Ribble Valley Borough Council
Development Control
Council Offices Church Walk
Clitheroe
Lancashire
BB7 2RA

Our ref: NO/2021/113355/02-L02
Your ref: 3/2021/0205
Date: 21 April 2021

**ERECTION OF 36 RESIDENTIAL DWELLINGS, ALONG WITH LANDSCAPING AND ASSOCIATED SITE INFRASTRUCTURE.
LAND AT NEDDY LANE, BILLINGTON, BB7 9LL**

Environment Agency position

Drawing Title: **Boundary Treatment Layout**

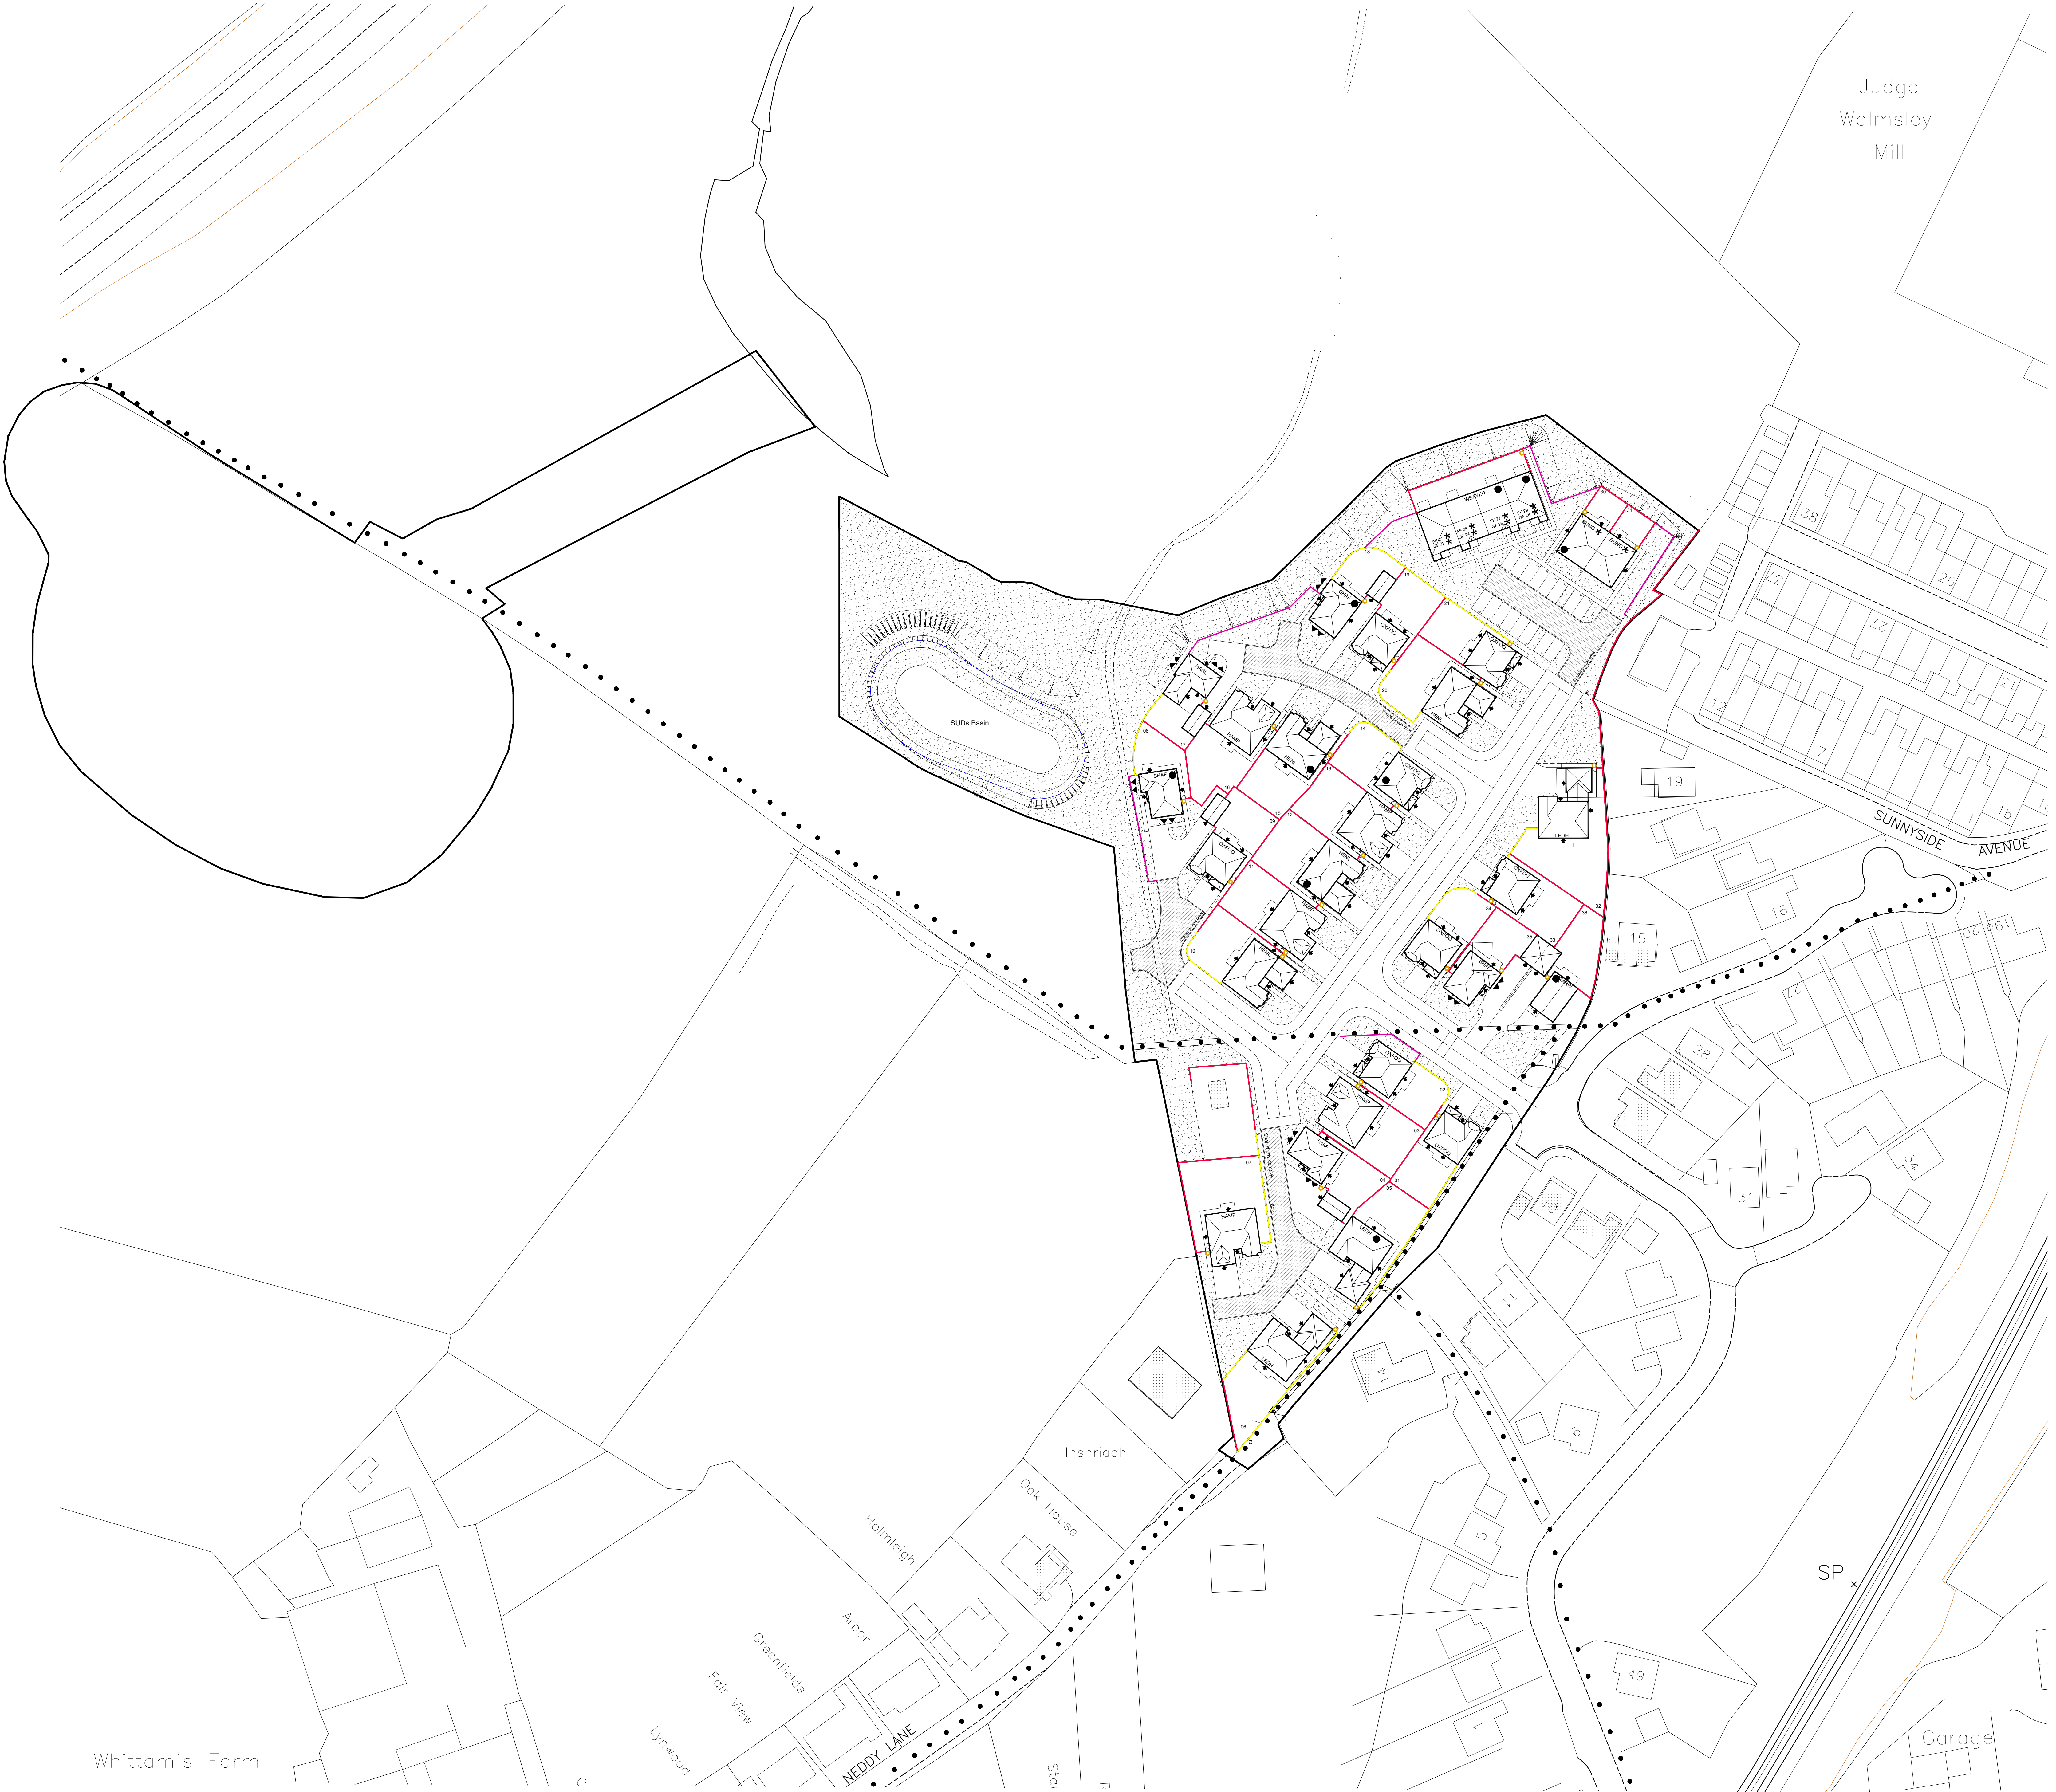
Clarity needs to be provided regarding the compensatory storage scheme, however it appears that the boundary treatments show that boarded fencing will be used within the 1,000-year extent. This means that the free flow of water will be restricted within the floodplain.
